# Tallawong Station Precinct South

Response to Submissions: Engineering Items

Client: Landcom

17-Oct-2018

60558549-SHT-00-0000-CI-0804

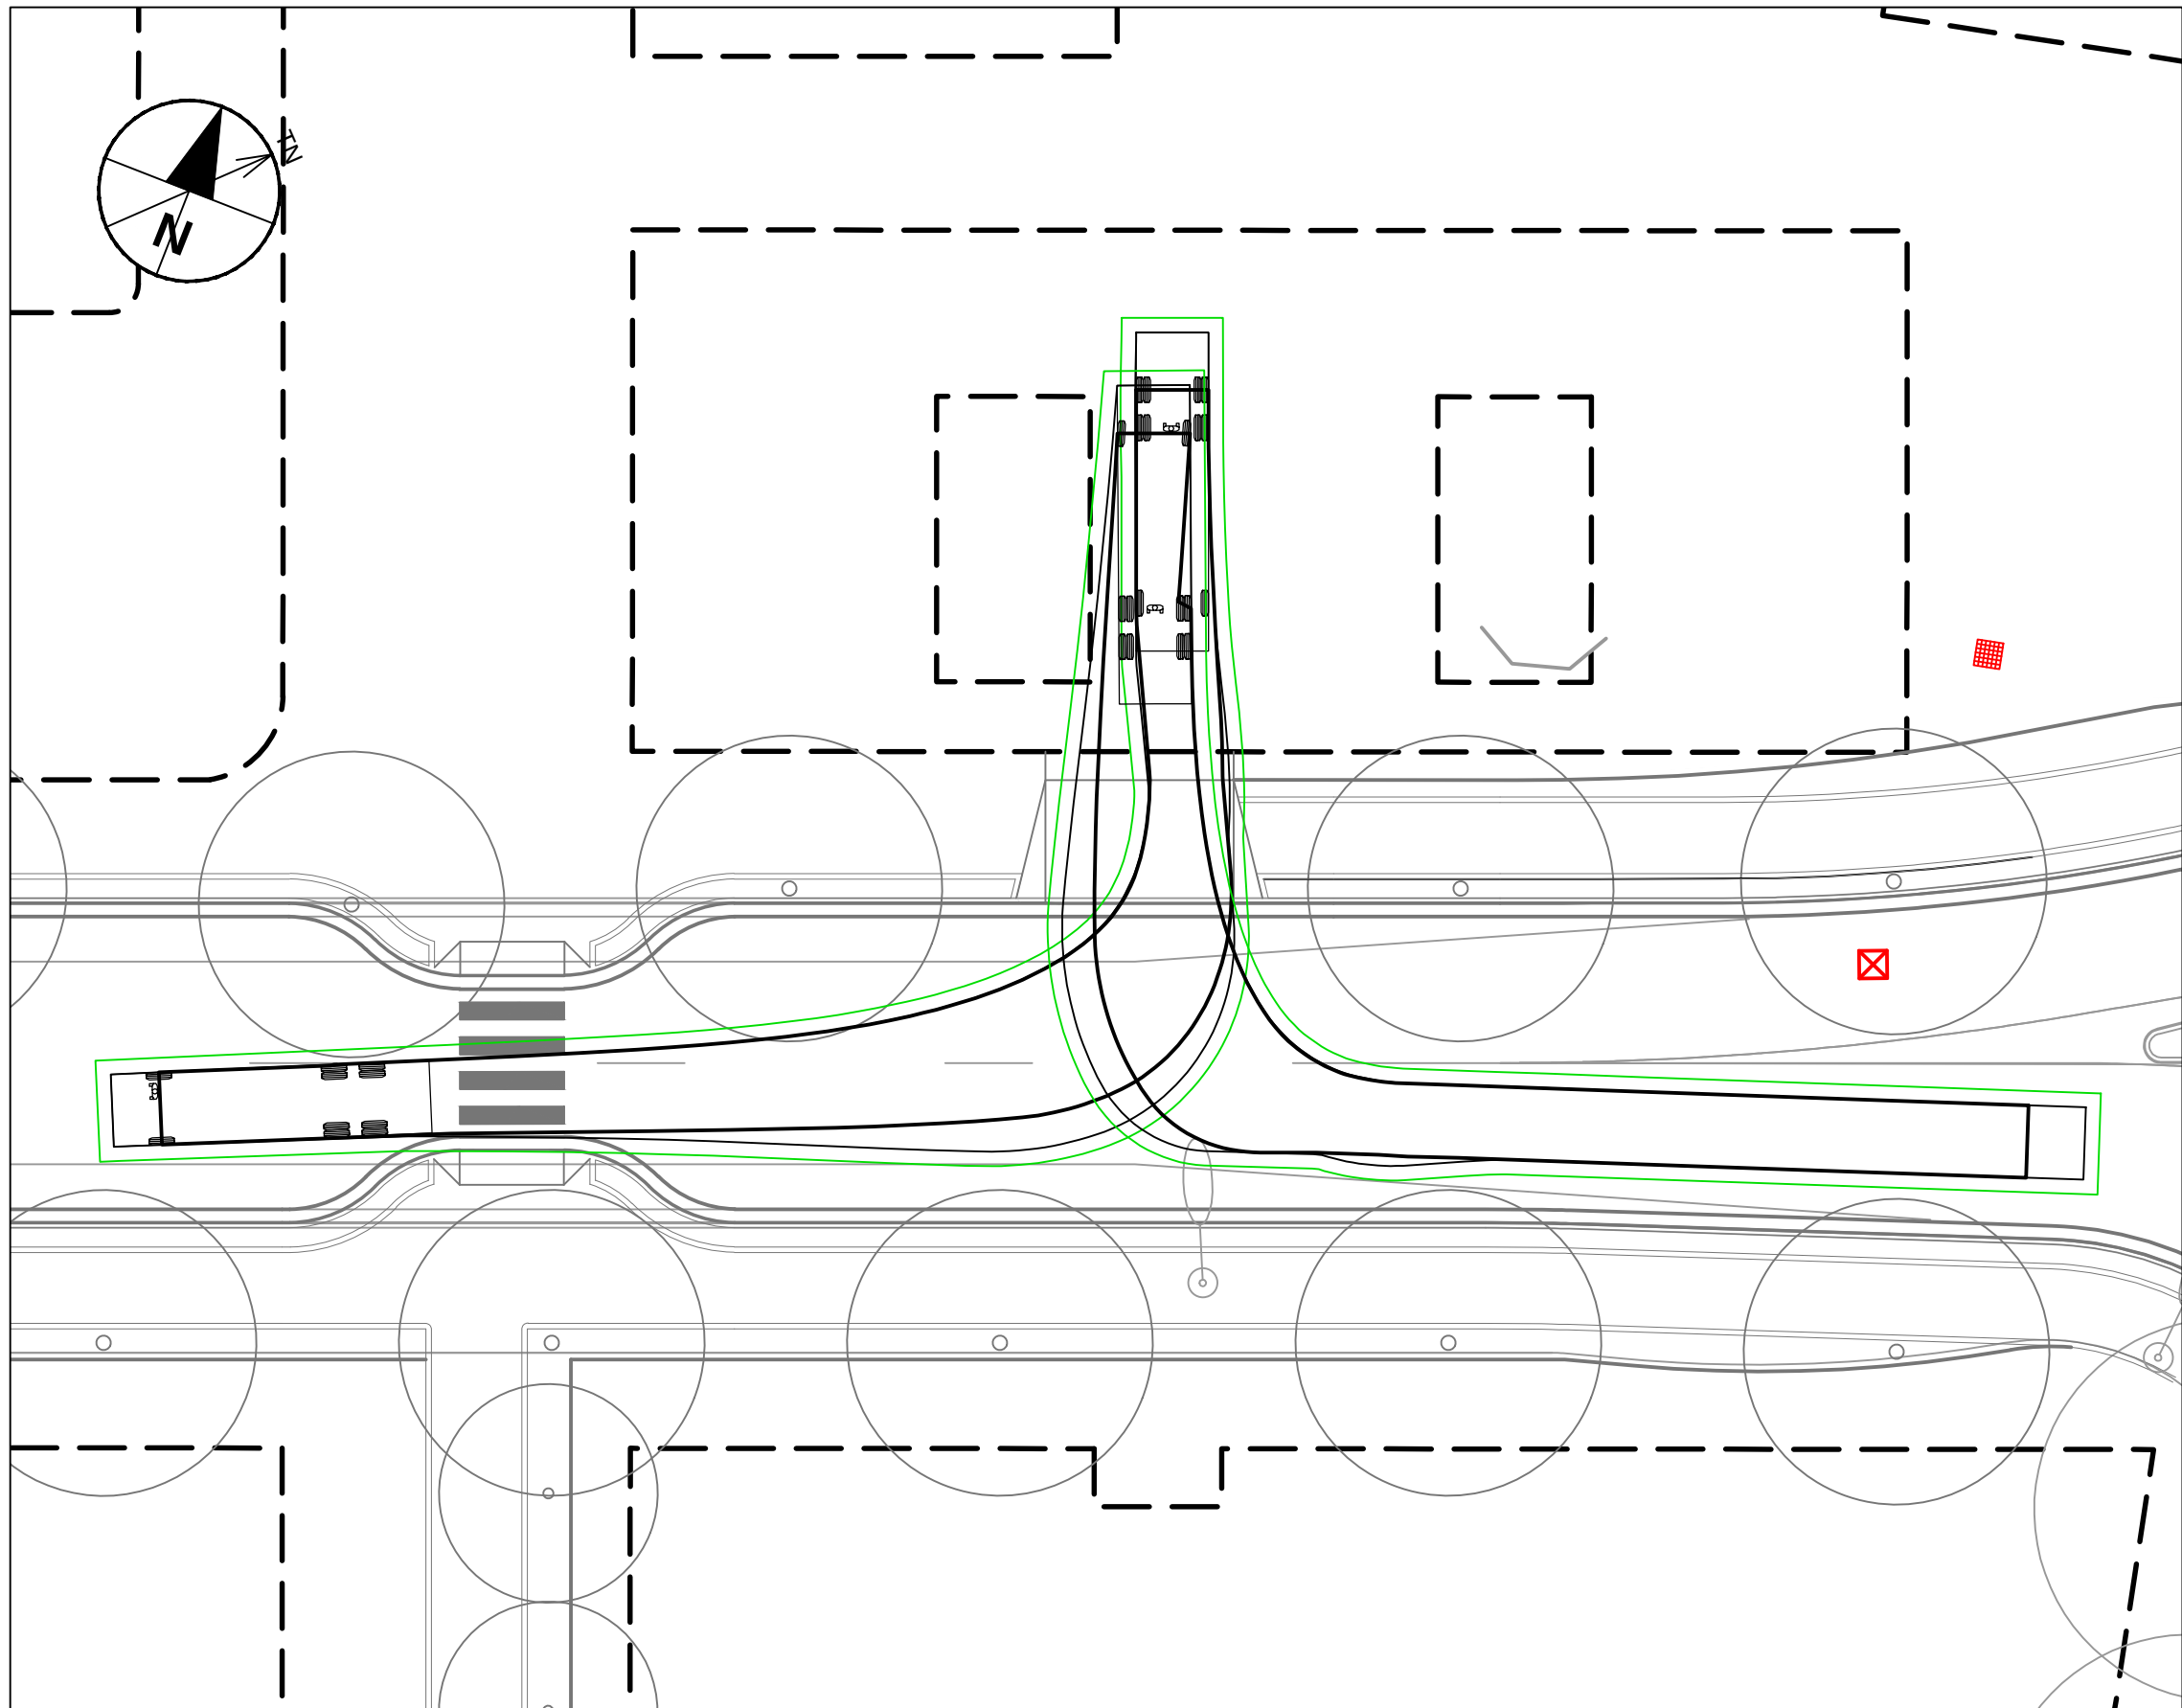
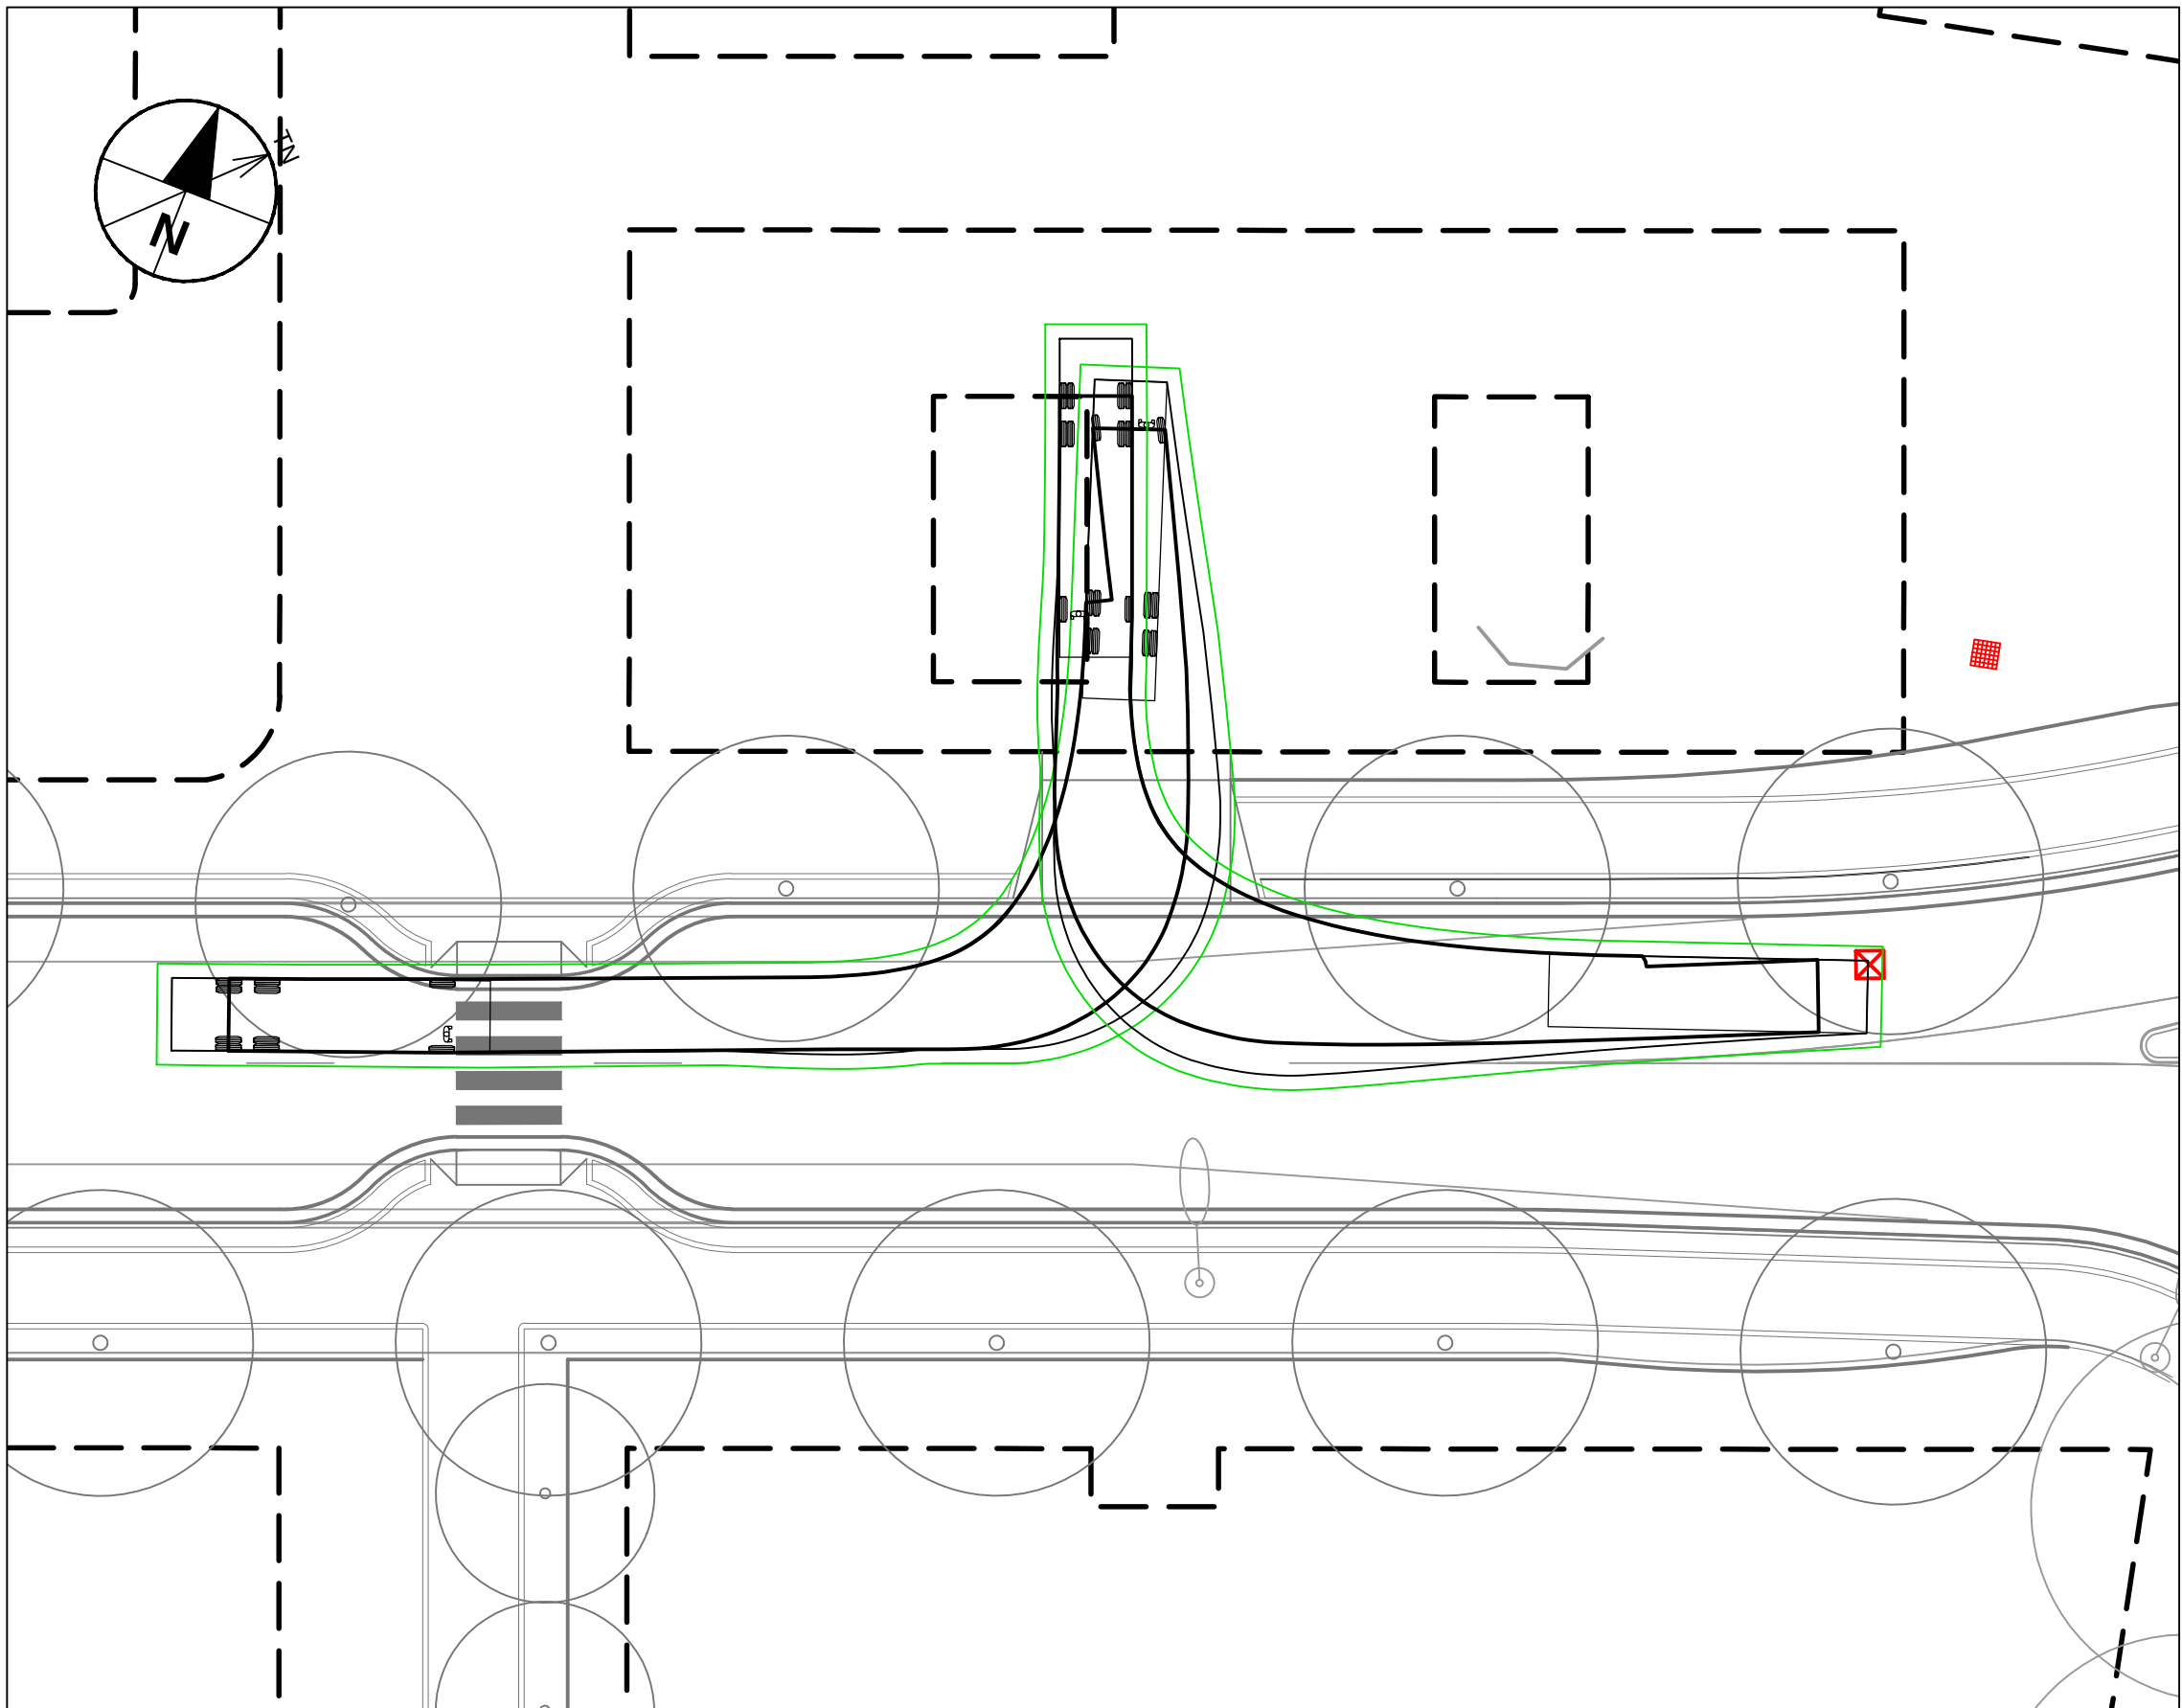
*vi. Demonstrate that the proposed 3.0m lane widths are adequate for larger vehicles such as buses, refuse and service vehicles*

These tracking plans demonstrate that the proposed 3.0m lane widths are adequate for larger vehicles such as buses, refuse and service vehicles.
